Recommendation Report for Planning Permission for Works or Extension to a Dwelling

REF NO: EP/148/18/HH

LOCATION: 86 Sea Road
East Preston
BN16 1NP

PROPOSAL: Single storey rear extension and two storey front extension

ARW Design	DRAWING TITLE: PROPOSED FLOOR PLANS PROJECT: PROPOSED SINGLE STOREY REAR EXTENSION & TWO STOREY FRONT EXTENSION		LOCATION: 86, SEA ROAD, EAST PRESTON, WEST SUSSEX CLIENT: J. & D. COULSON		SCALE: AS NOTED @ paper size A3 DATE: OCT 2018		DRAWING NO: 4393/1
					DRAWN: ARW		
					REVISION:

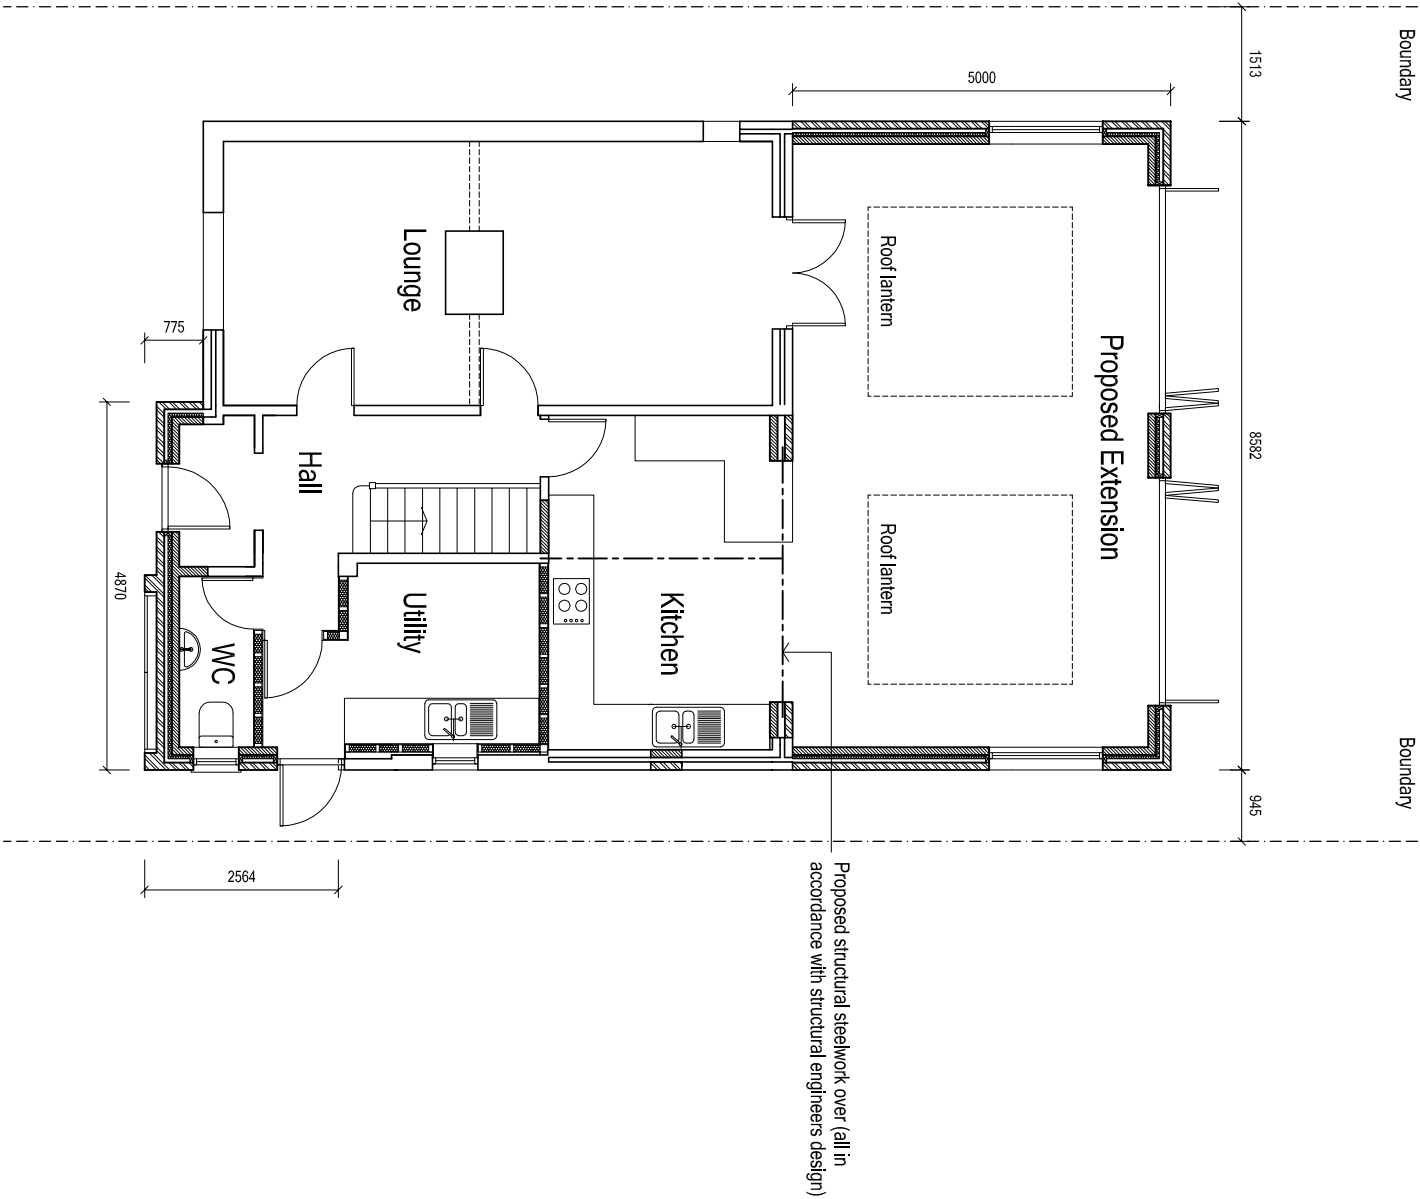
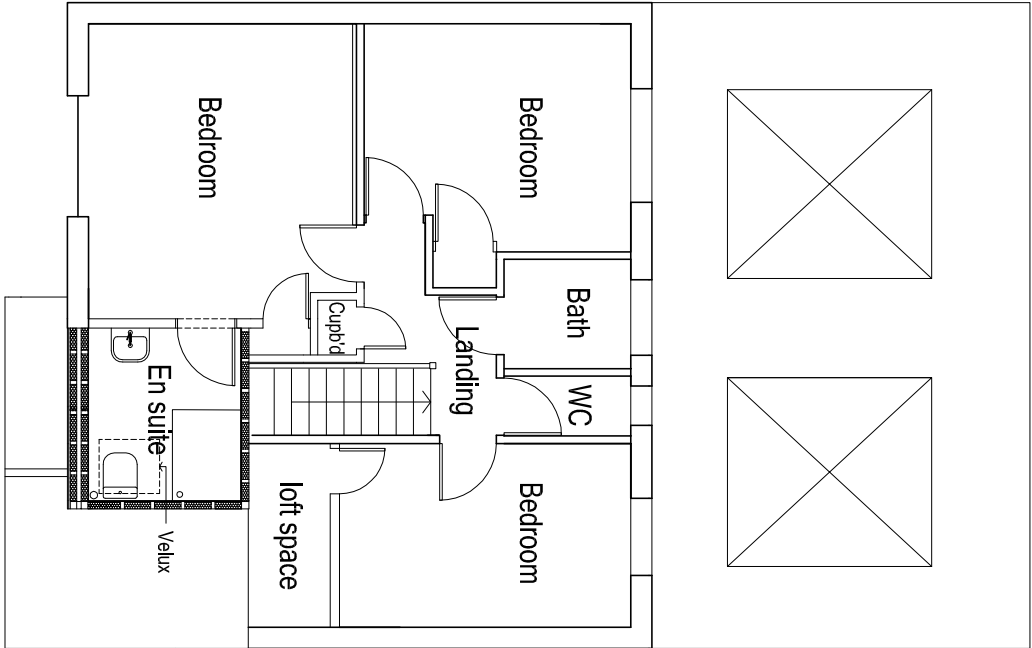
The proposed rear extension is not considered to result in any significantly harmful impact on the neighbouring residential amenities of occupiers of adjacent dwellings. This is due to modest height of the extension, and the 0.95m separation distance to the Northern boundary not being considered to result in any significant overshadowing or overbearing impact on this adjacent occupier.

The proposed front extension is not considered to result in any significant overbearing or overshadowing impact on occupiers of adjacent dwellings. This is because the proposal comes forward of the host

dwelling, therefore any overshadowing would be to the South-Western part of the dwelling to the North, which features no windows to principle habitable rooms. This aspect of the development features a rooflight, which provides views to the North, where on the adjacent dwelling, there is a window serving a principally habitable bedroom. Therefore, it is recommended that a condition be imposed that ensures that the window be obscure glazed and non-opening below 1.7m.

ARW Design	DRAWING TITLE: PROPOSED ELEVATIONS		LOCATION: 86, SEA ROAD, EAST PRESTON, WEST SUSSEX CLIENT: J. & D. COULSON	SCALE: AS NOTED @ paper size A3 DATE: OCT 2018	DRAWN: ARW	DRAWING NO: 4393/2
	PROJECT: PROPOSED SINGLE STOREY REAR EXTENSION & TWO STOREY FRONT EXTENSION					
	REVISION:

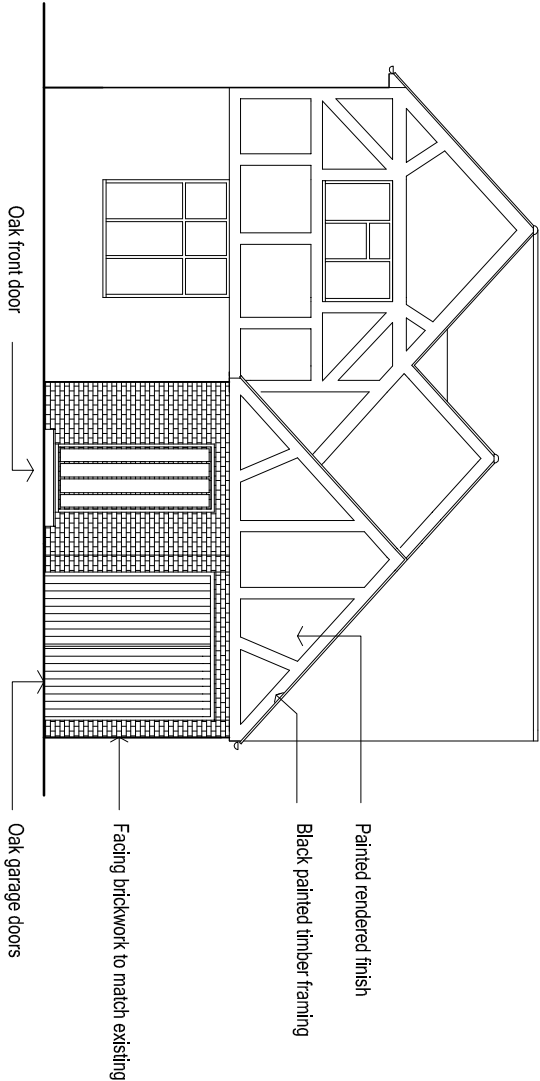
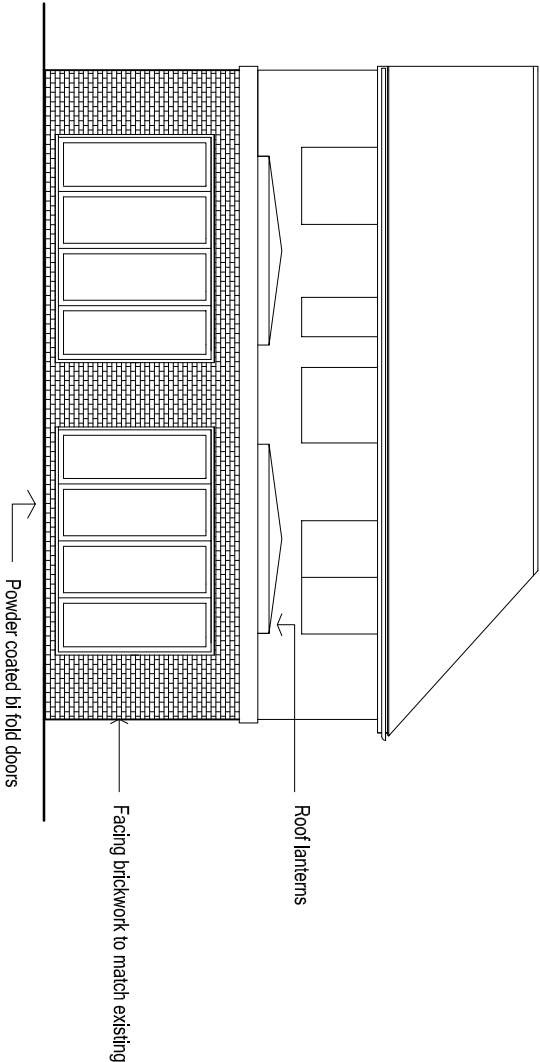
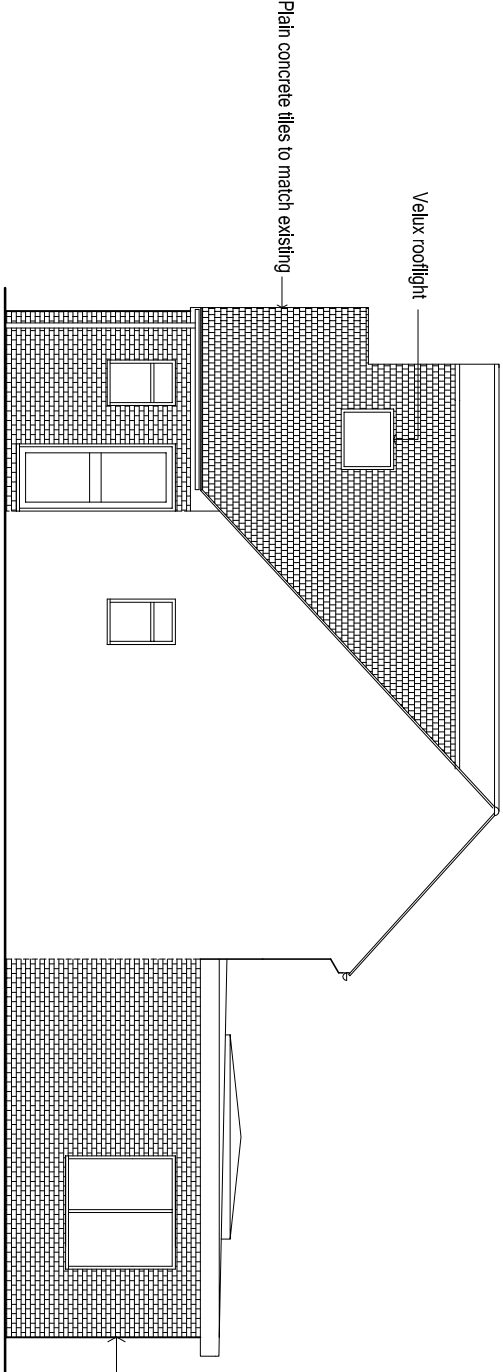
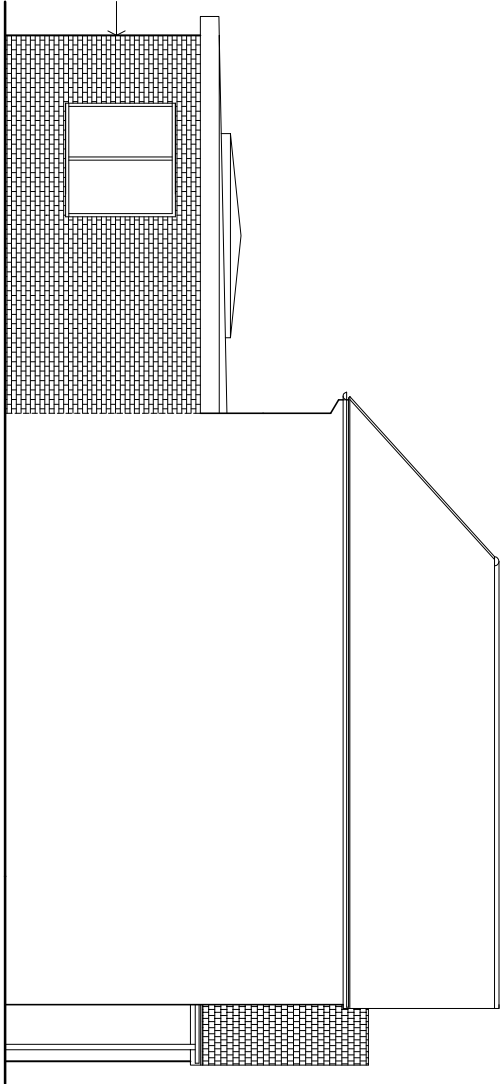
The proposed front extension is visible from the street scene, and is considered to be a significant change to the appearance of the host dwelling, however, it is important to note that this change is not necessarily harmful. The front extension is considered to be visually well integrated with the host dwelling, resultant of its design, use of materials and proposed roof slope angle. Therefore, whilst the proposed development is of a significant scale, its design and ridge height allow it to appear as a subservient and sympathetic addition to the host dwelling. Additionally, there are examples of similar development within the locality, like 90 Sea Road, which is considered to allow the proposal to have no significantly detrimental impact upon the established character of the locality.
